20 March 2017

Our Ref 160798

RE: Redevelopment of Harbourside Shopping Centre SSD 7874

Figure 8 – Sydney Water Closed Conduit Information

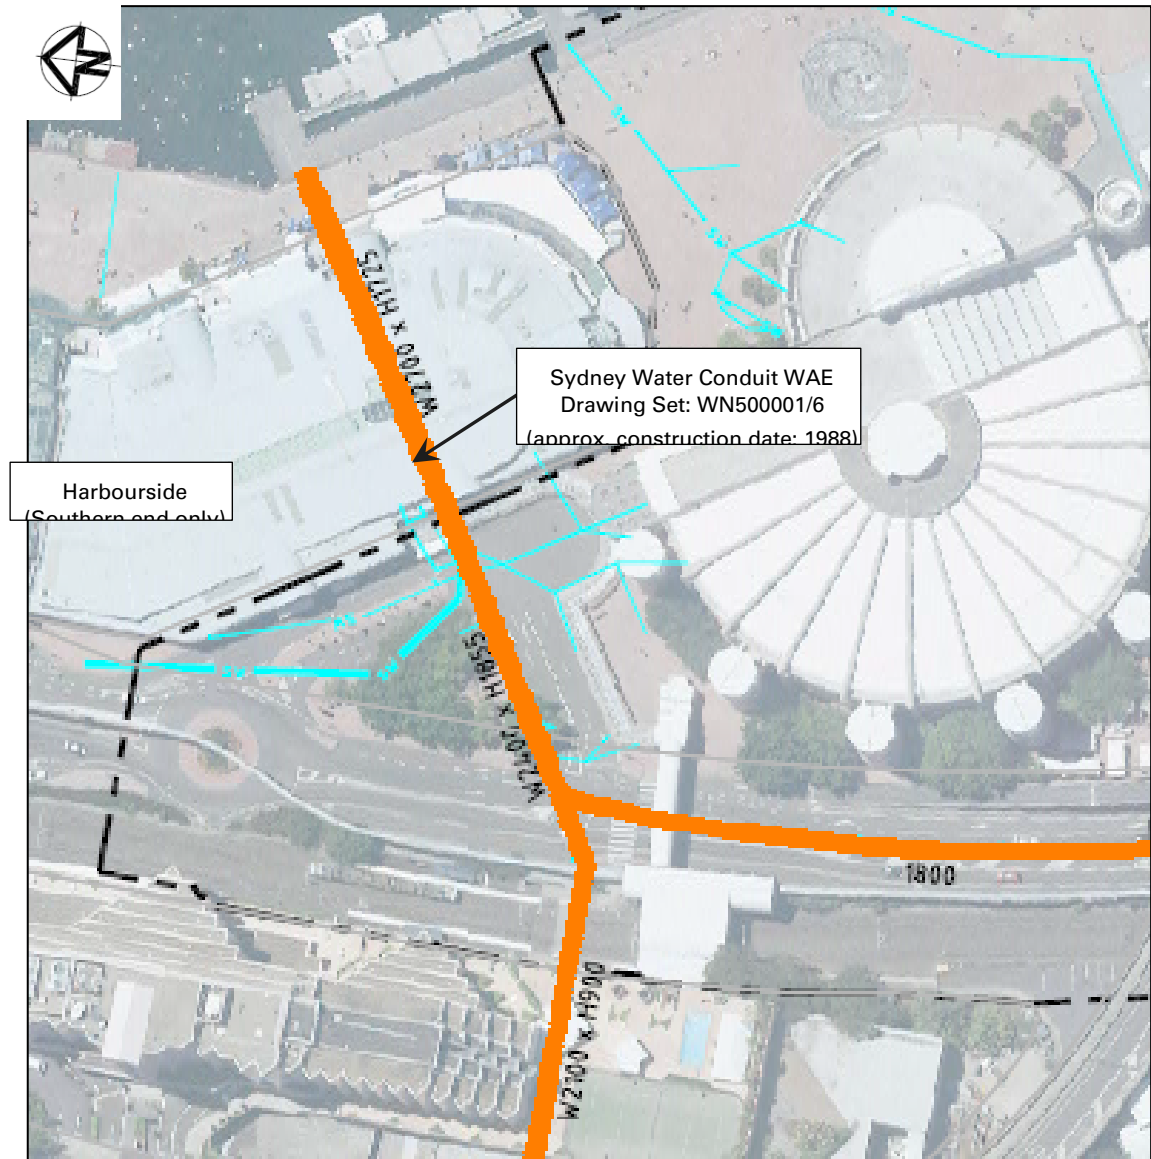
- The proposed development as understood will use the existing footprint. The existing structure is presently over an existing Sydney Water 2700 x 1725 RC Stormwater Channel and proposed redevelopment is also proposed to be constructed over this stormwater channel.

- The proponent is required to liaise with Sydney Water regarding the measures need to be taken prior to commencement of any works and the required protection measures which are to be implemented as part of this development.
